**Consultation Response from KC, Highways Development Management**
**2021/91757 The Old Pump House, Wakefield Road, Lepton, Huddersfield, HD8 0LY**
**Demolition of existing buildings and erection of two detached dwellings**
**Date Responded: 06/10/21    Responding Officer: J Turner    Responding Ref: K16-1/1**

1 SITE PLAN AS PROPOSED
SCALE 1:500

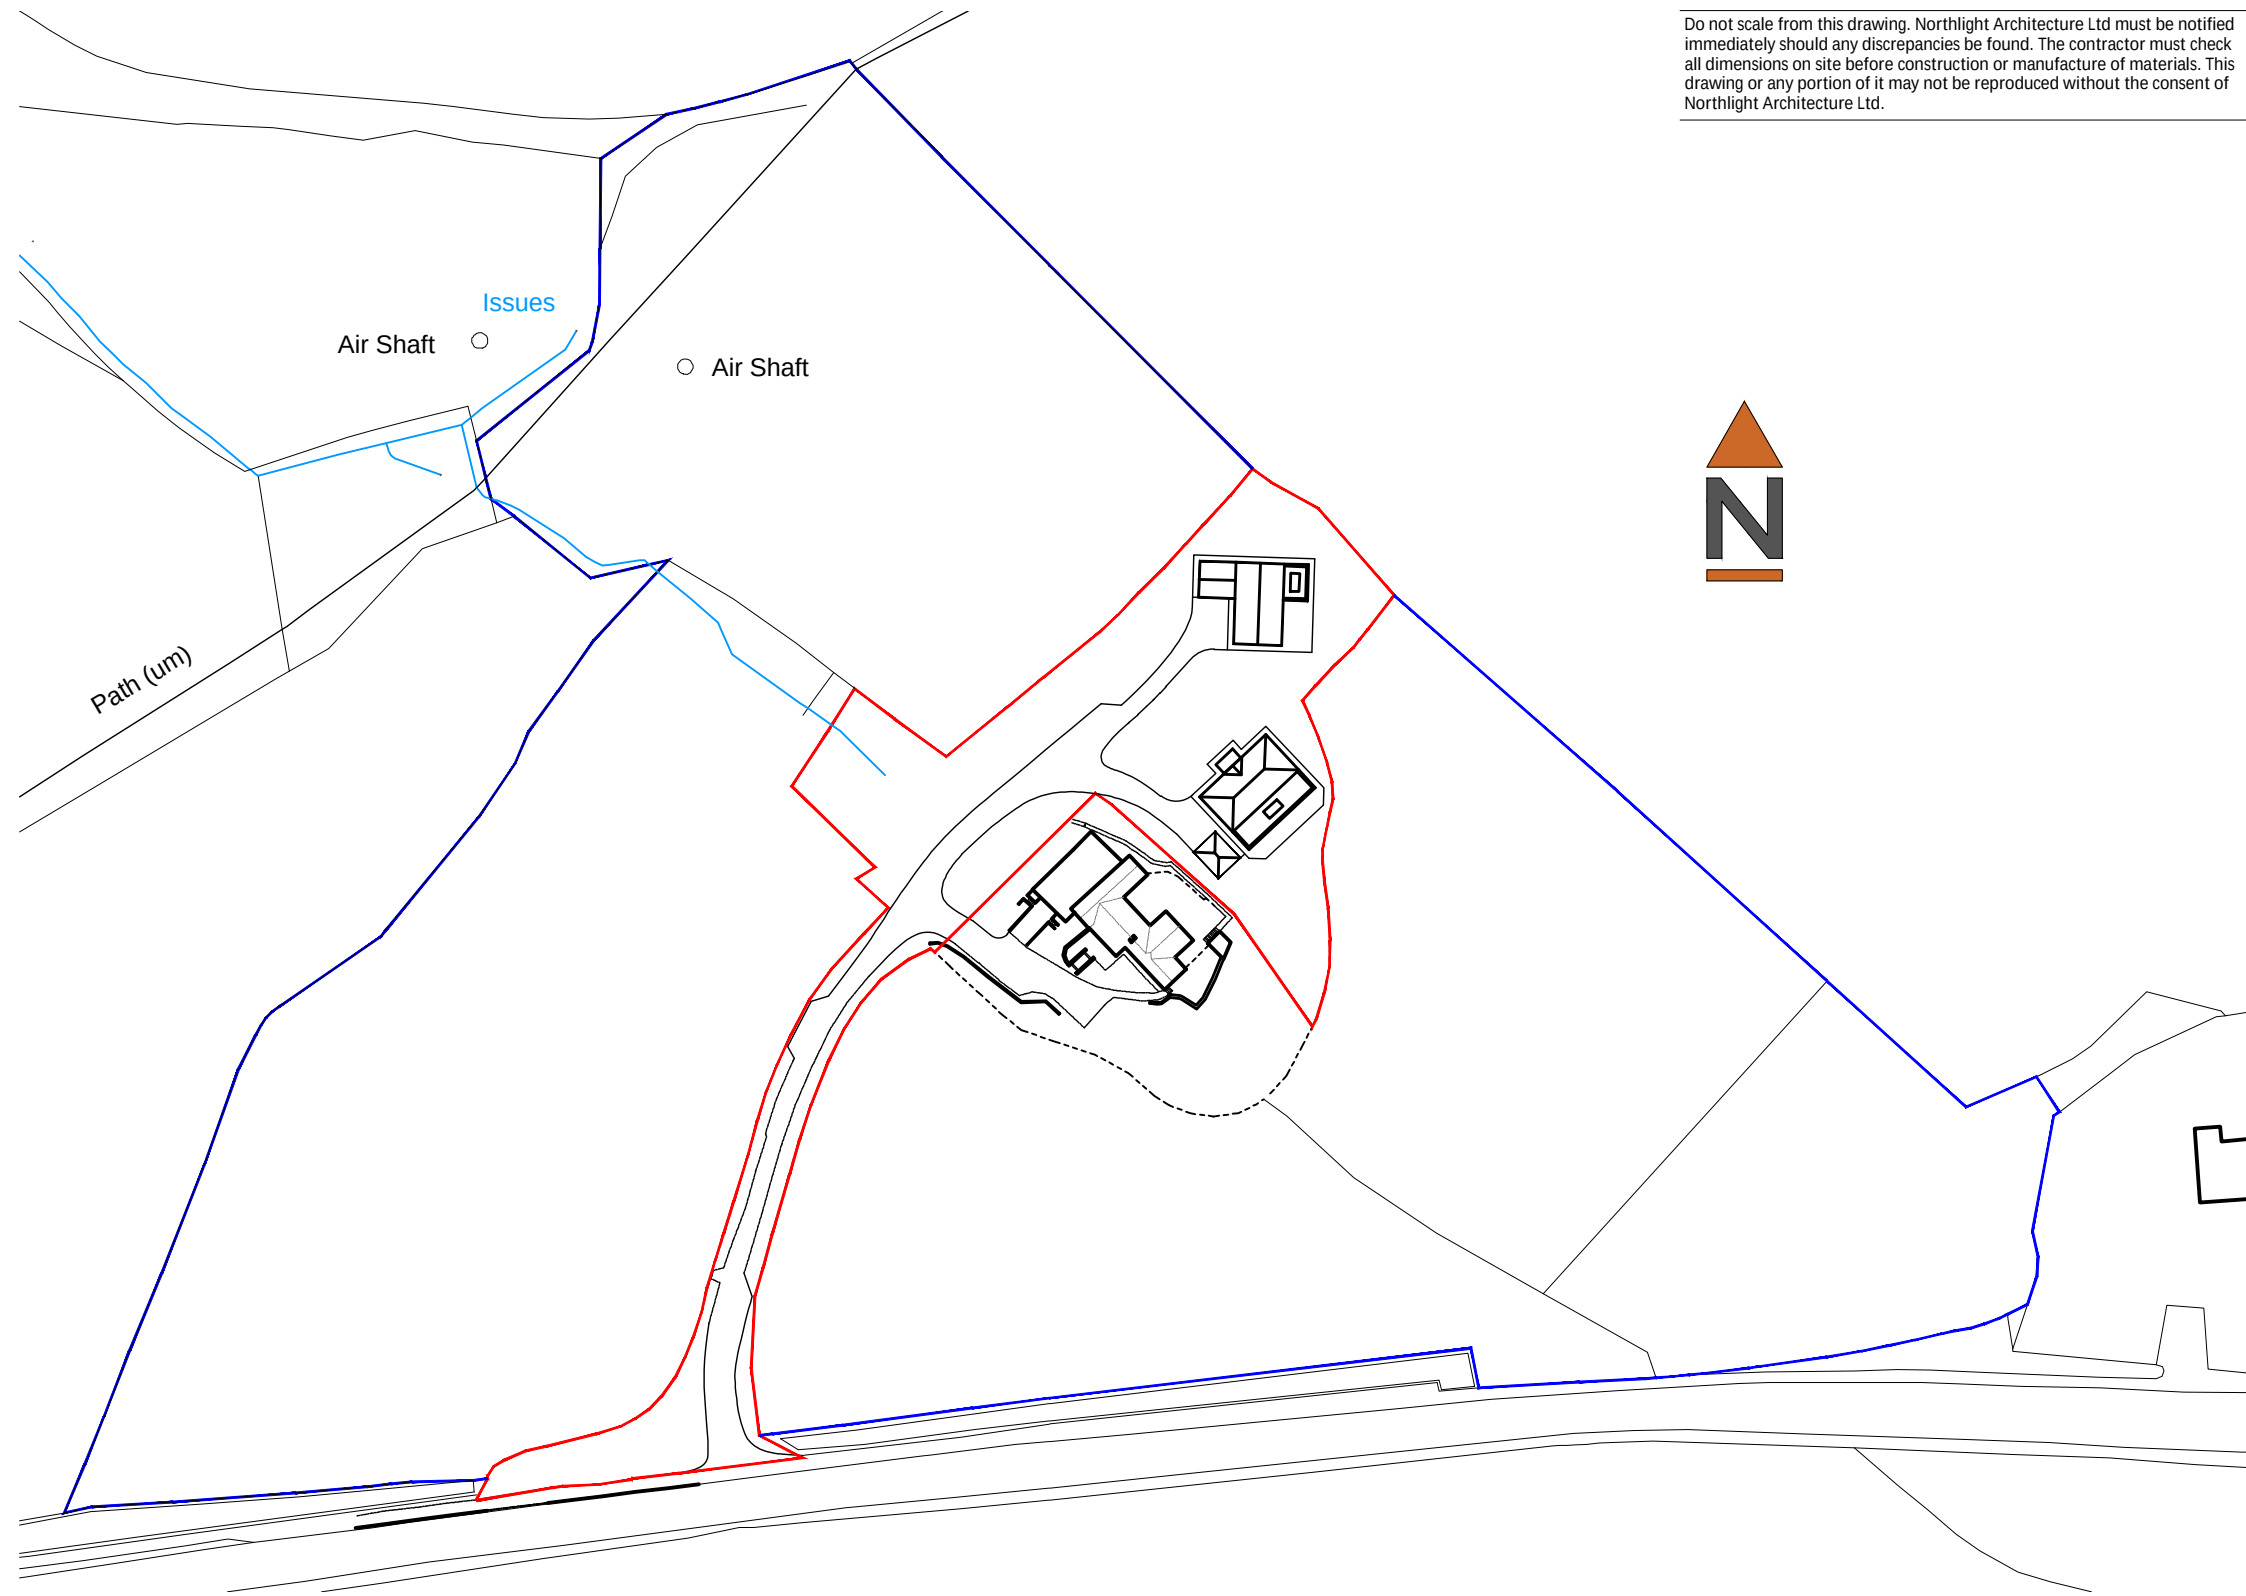
Although the information has now been put in writing on drawing number mkcl-121-C1, it hasn't actually been demonstrated in the proposed layout. For the most part, the matters can be conditioned, but the final point regarding emergency access should be properly addressed prior to final highway comments and suggested conditions being made.

- Emergency vehicle access details demonstrated including internal turning of a fire tender or alternative arrangements made (i.e. a dry riser installed).
